Our Ref: R/130/19/PL

**Town & Country Planning Act 1990 (as amended)
Town and Country Planning (Development Management Procedure) (England) Order 2015
Application for Planning Permission**

Development Application for variation of a condition following grant of planning permission
R/190/18/PL relating to condition no.2 - amended access points

Location St Marys Close Hurst Road Rustington

ADDITIONAL 2 DWELLINGS
BLOCK/ SITE PLAN

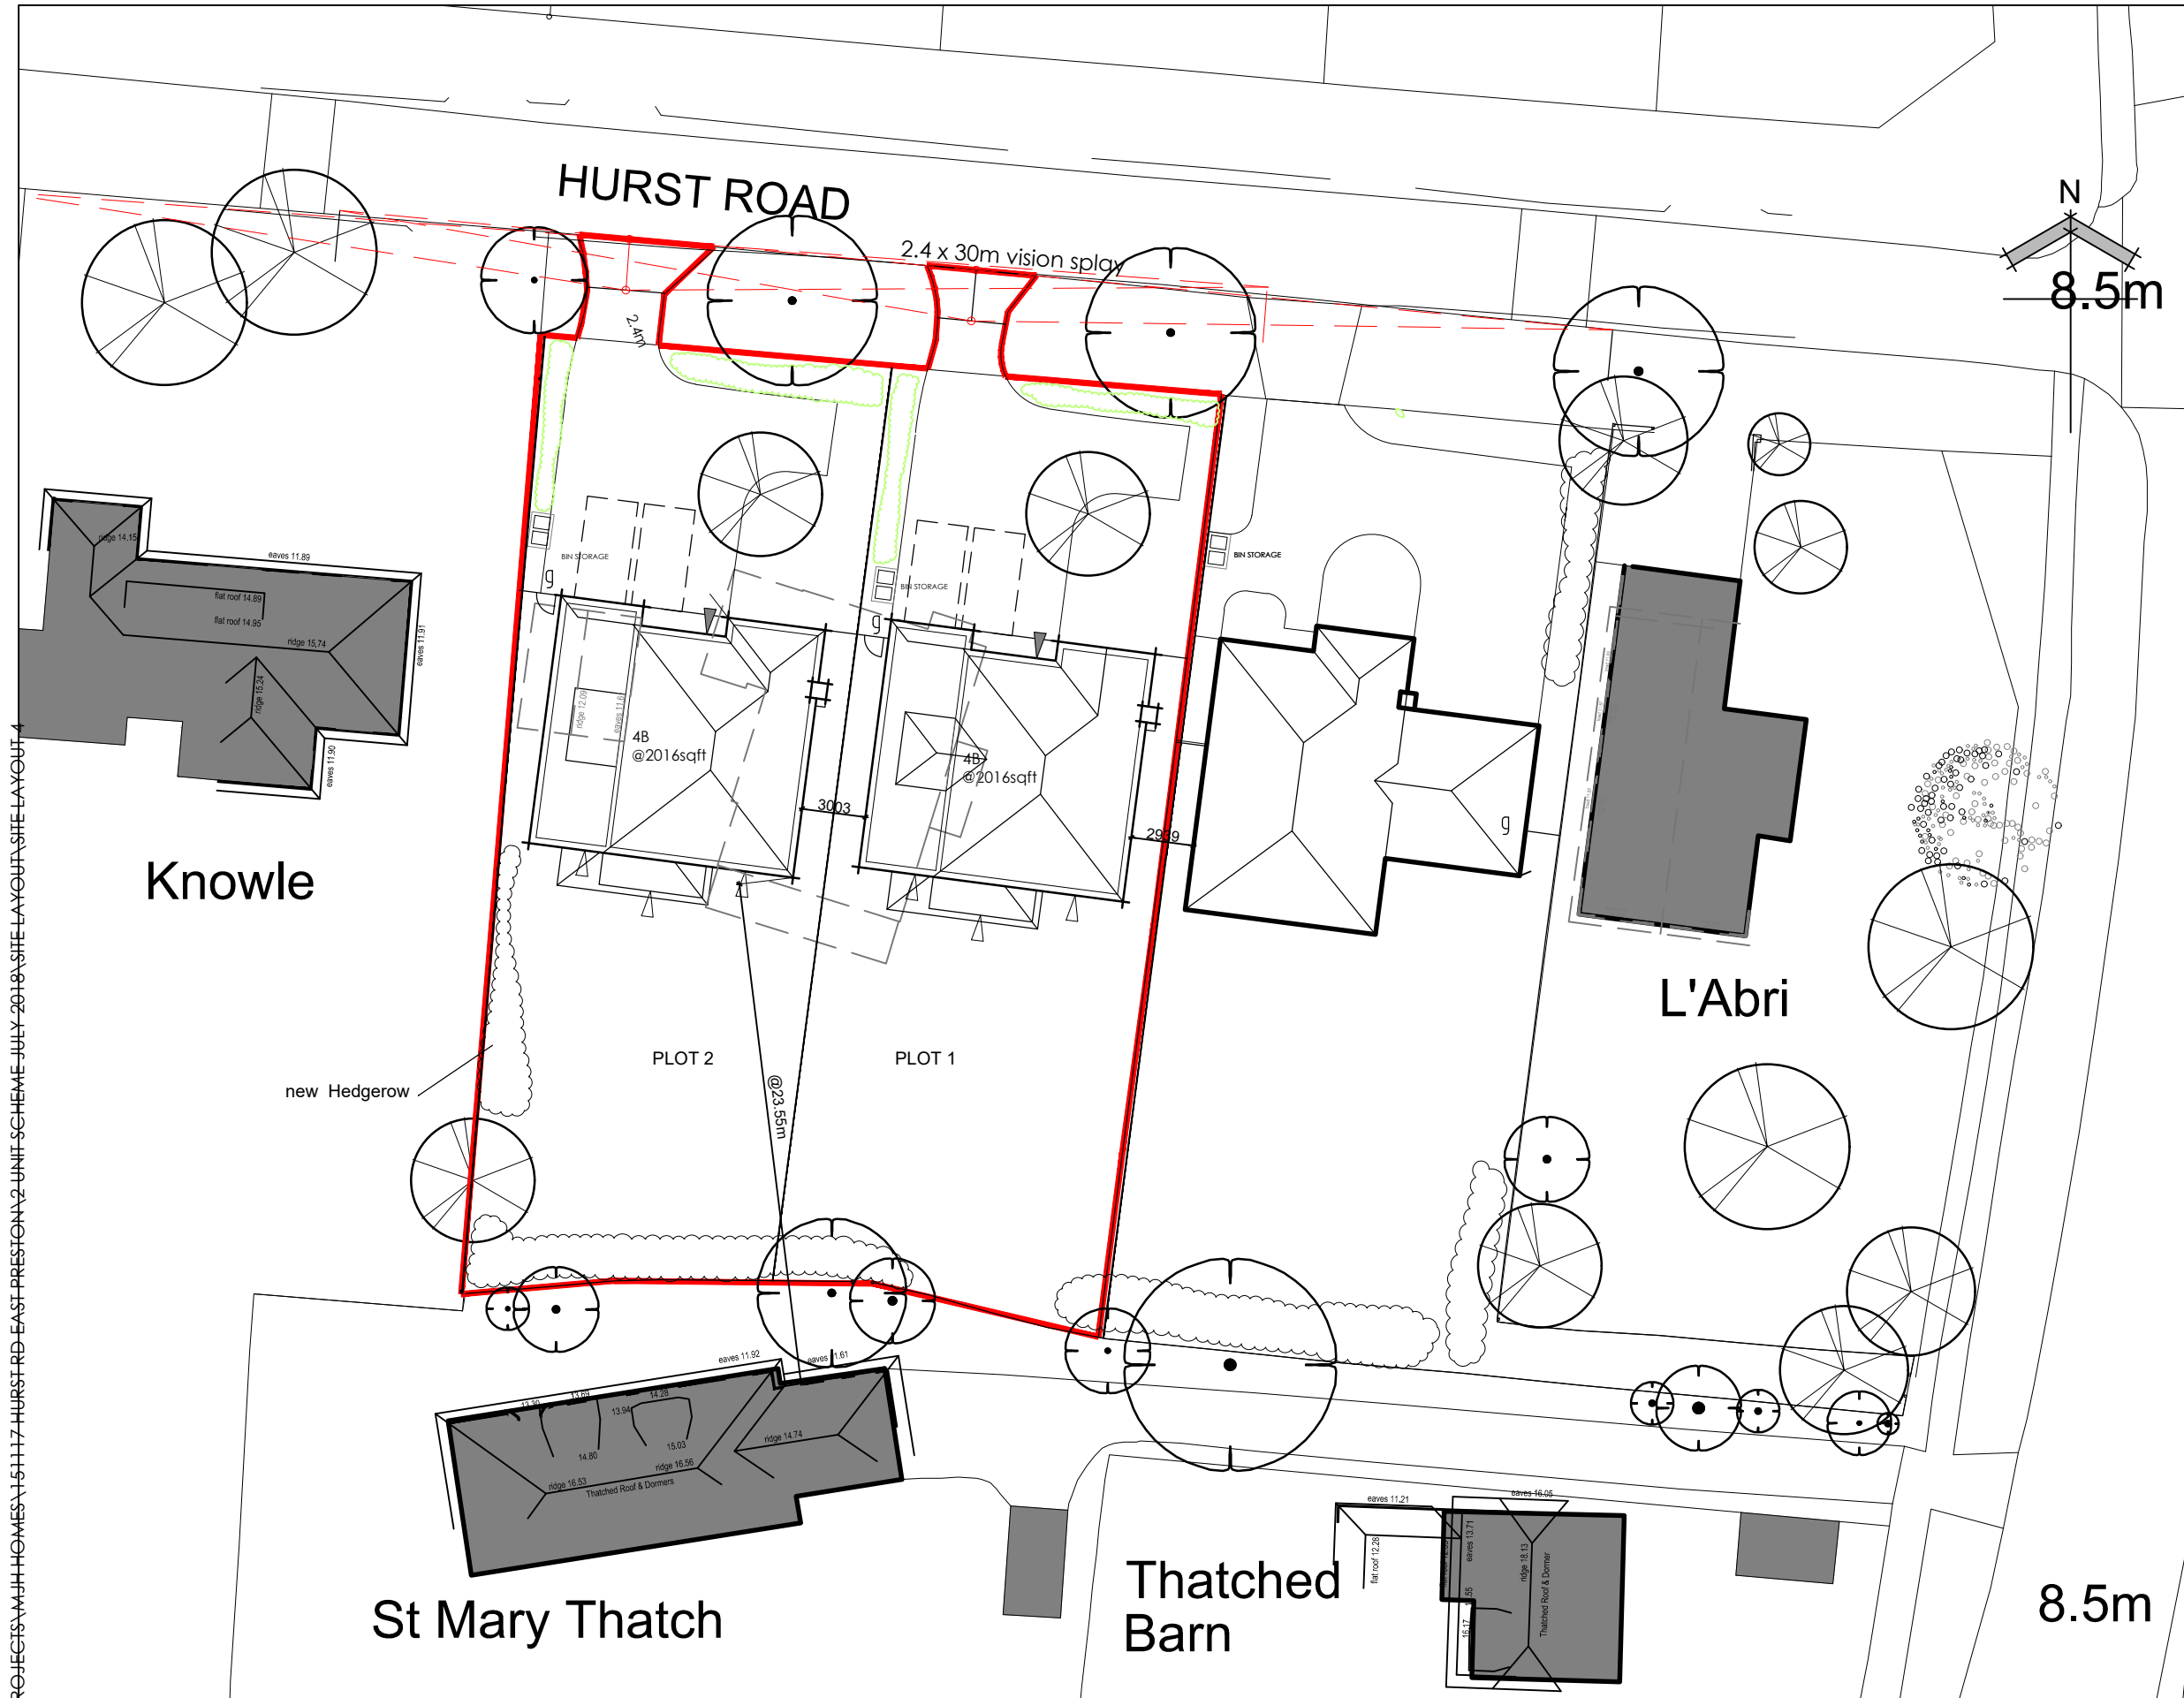
The location and block plans must include the access points and visibility spays within the site area as per the guidance notes available online. Please therefore forward amended plans to include this area within the red edge
